From: Anita Gardner
Sent: 28 February 2018 12:51
To: Karen Parsons
Subject: FW: FW: New Barn, Ryebank Farm, Climping

I am still awaiting the revised written comments of the Conservation officer and I am not in the office the rest of this week. I would therefore be grateful for your agreement to a further extension of time on the application until 09-03-2018.

Subject: Ryebank Barn, Climping

RE: New Barn, Ryebank Farm, Climping

Drawing Title
Proposed Drawing
Ground Floor Plan, First Floor Plan, South and
West Elevations 1/100 @ A1

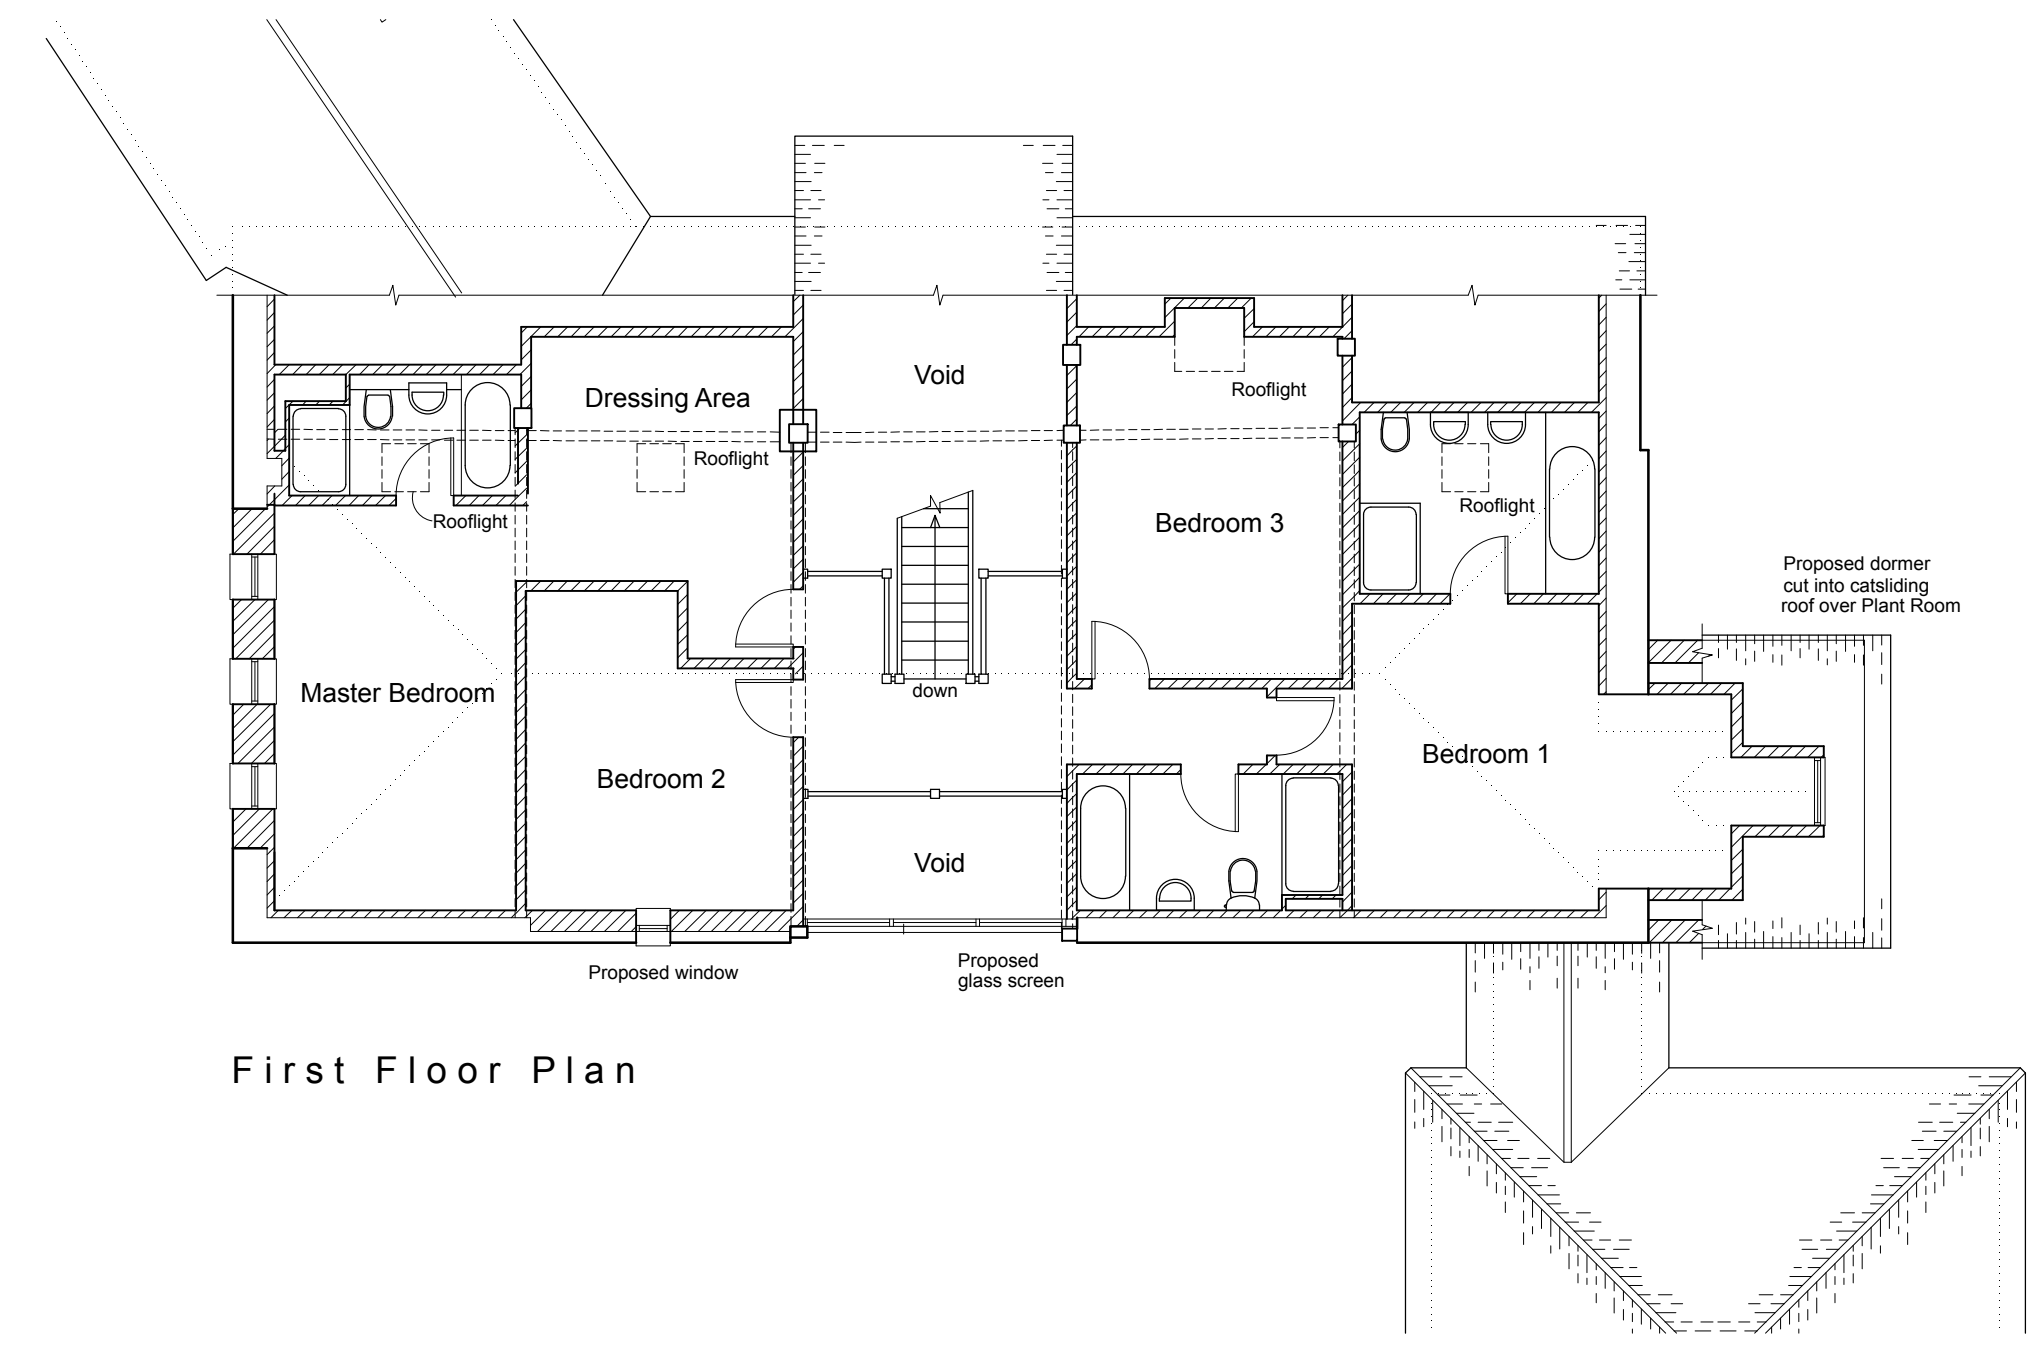
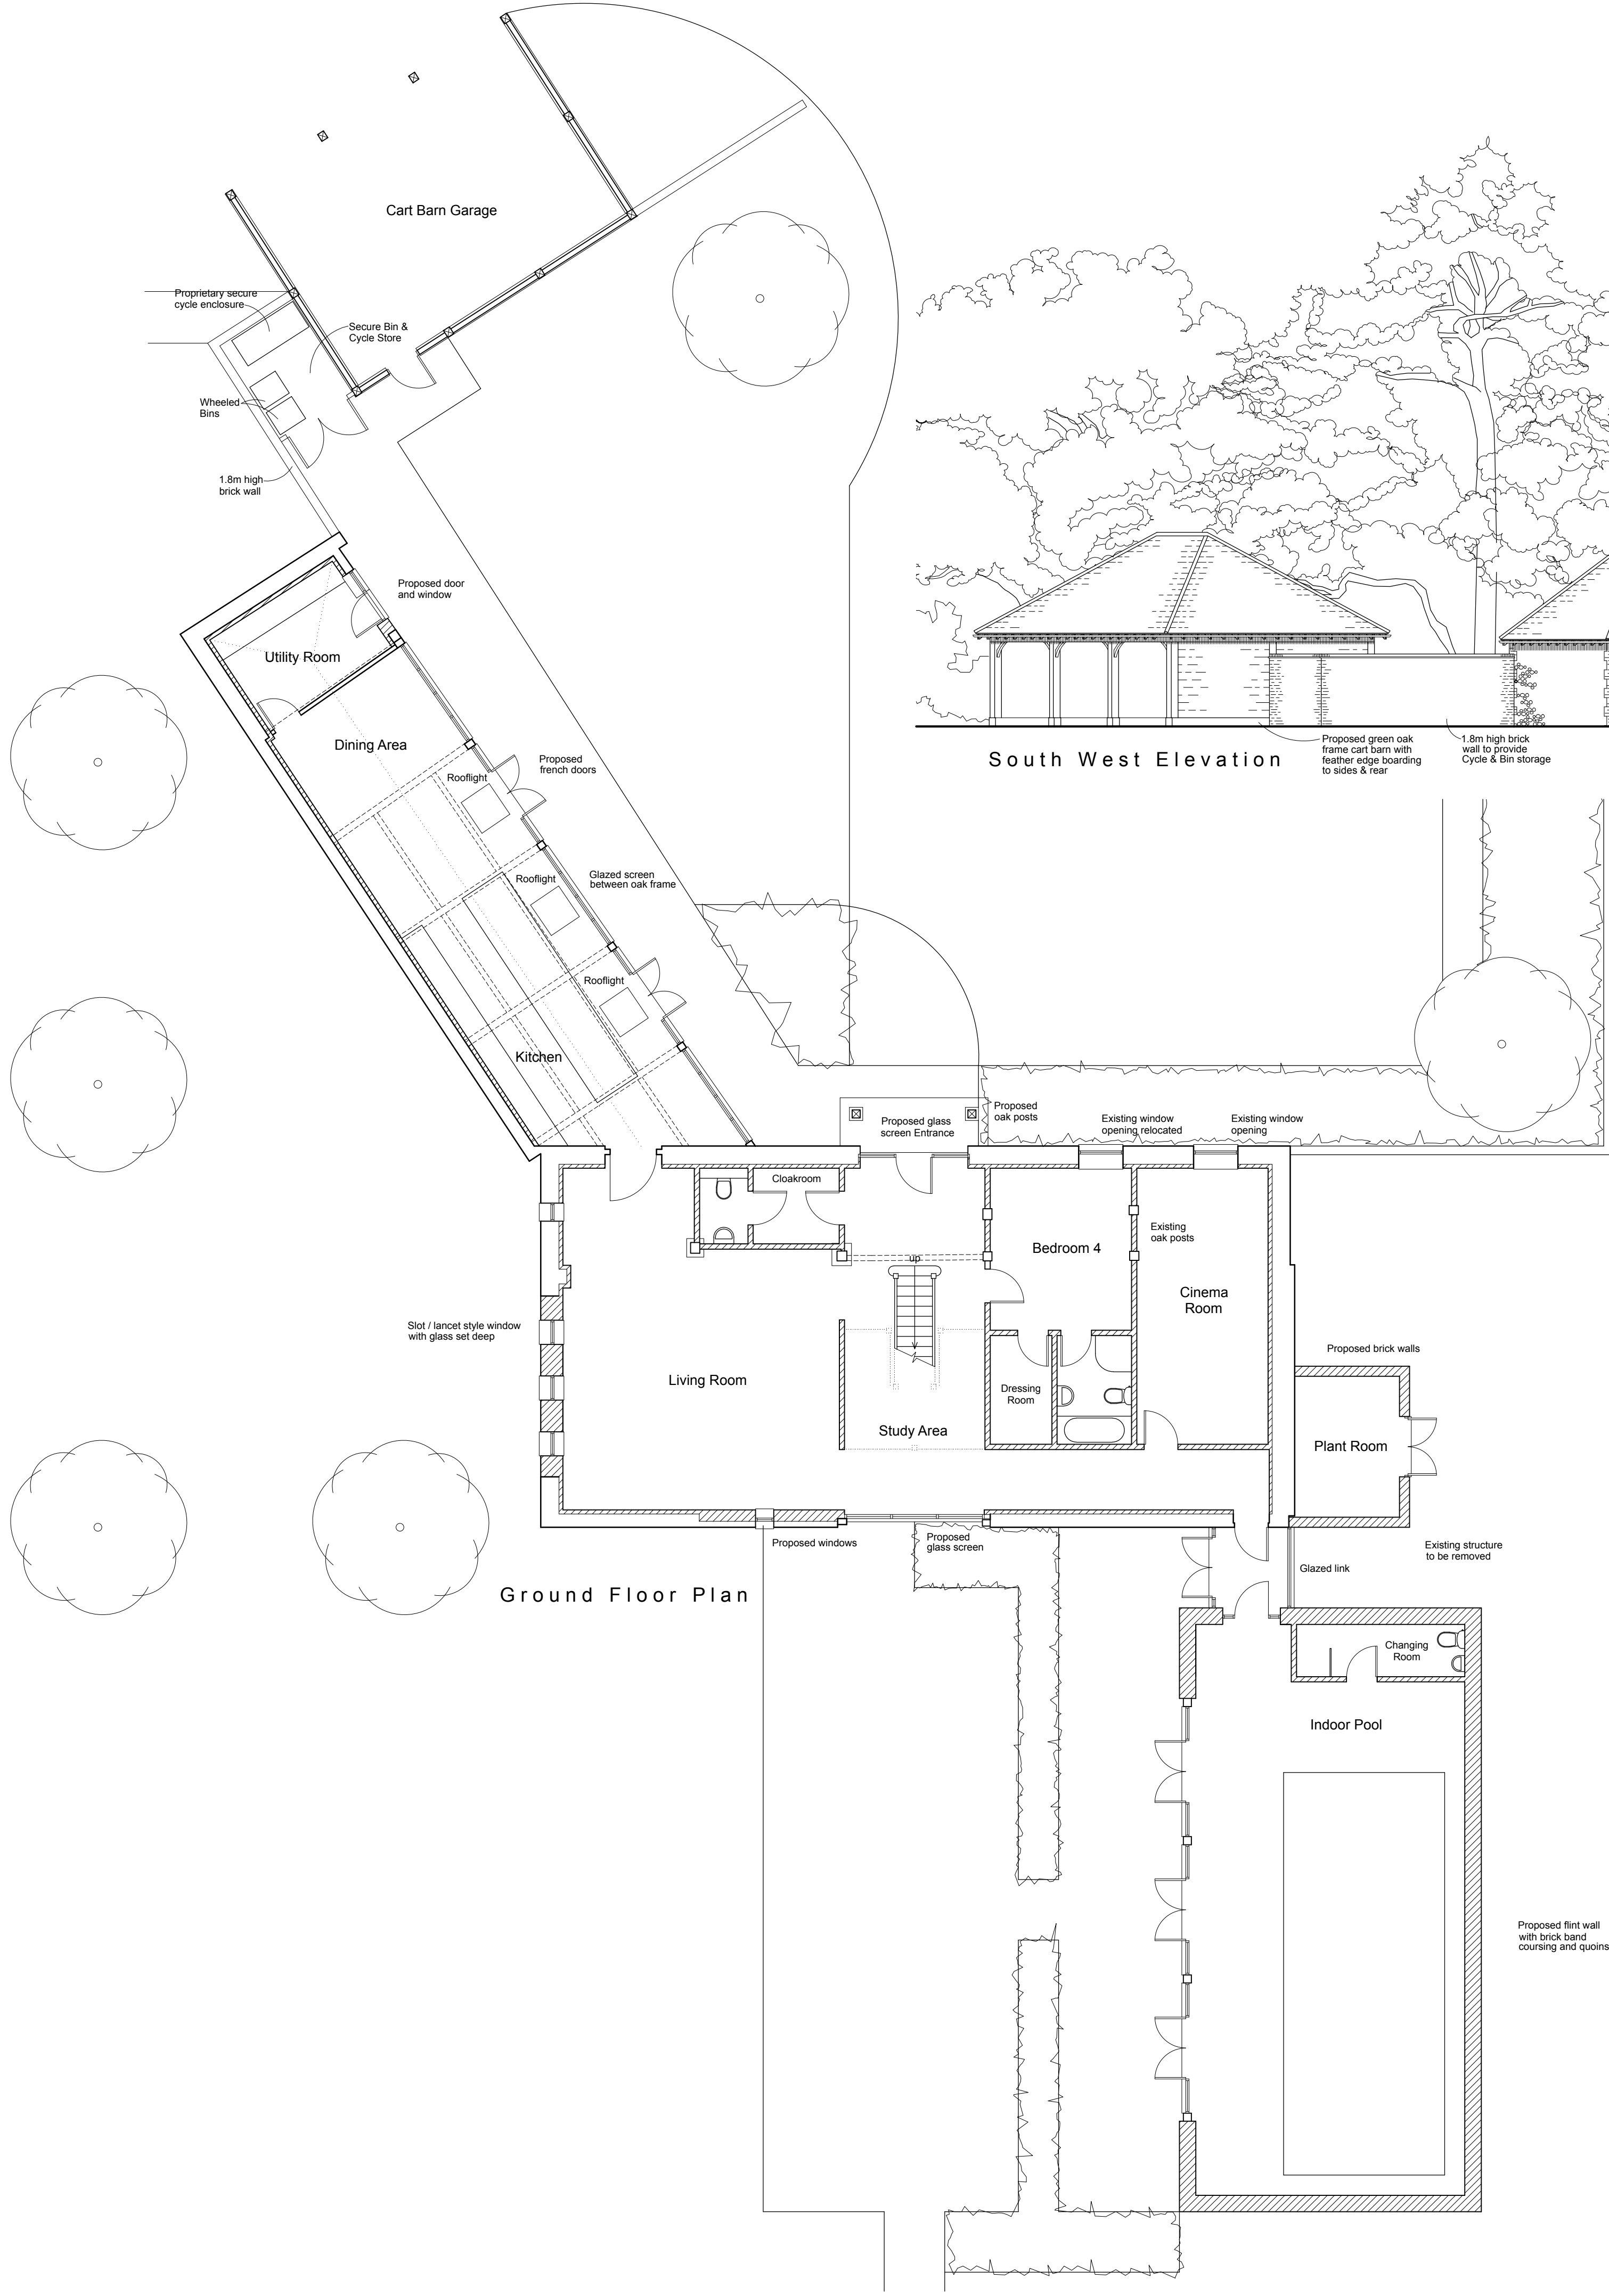
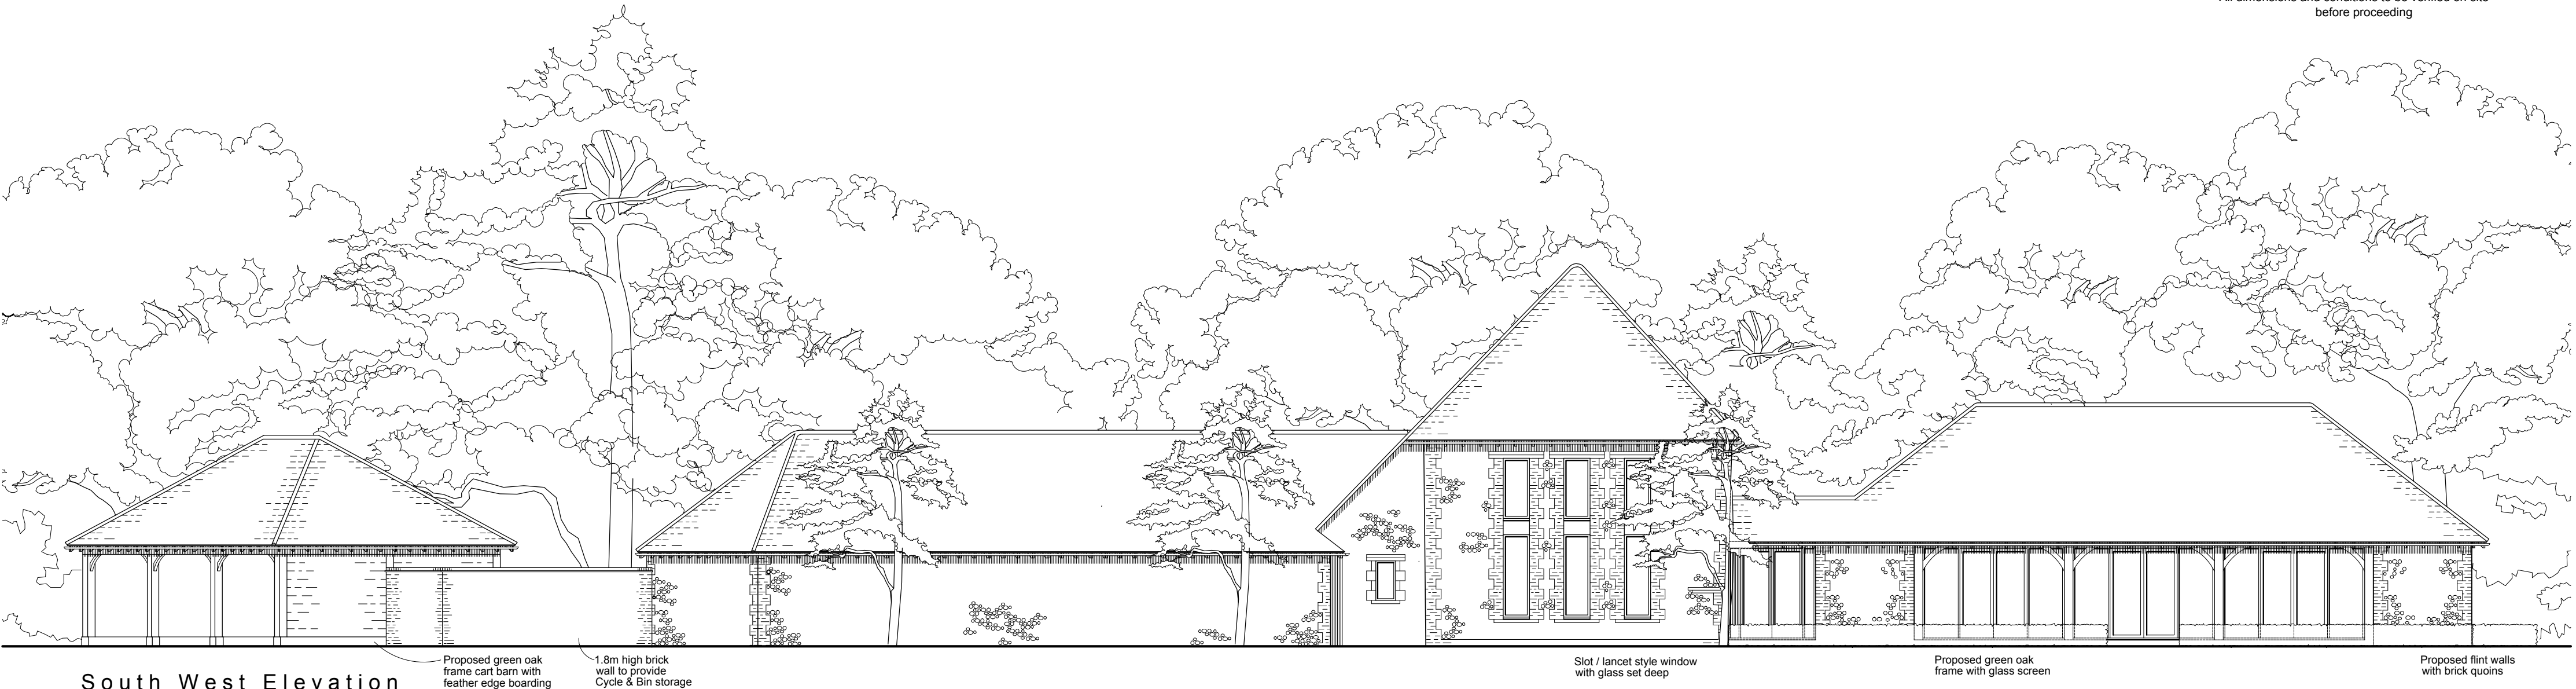
With respect to the alterations to the main barn our main concern externally is the porch which might give the building a more domestic feel. We appreciate that there may be a desire to create a sense of entrance, however we would ideally want this to be more understated. We have similar concerns with the dormer, though wonder if this could be simply amended by changing the triple casement to a taller and narrower opening.

Other minor observations relate to the thin windows in the timber cladding of the south elevation. We wonder if these three windows could be rationalized to appear less abstract. We would also prefer to see the (top left) roof light in the north elevation either removed or moved. It seems quite close to the corner.
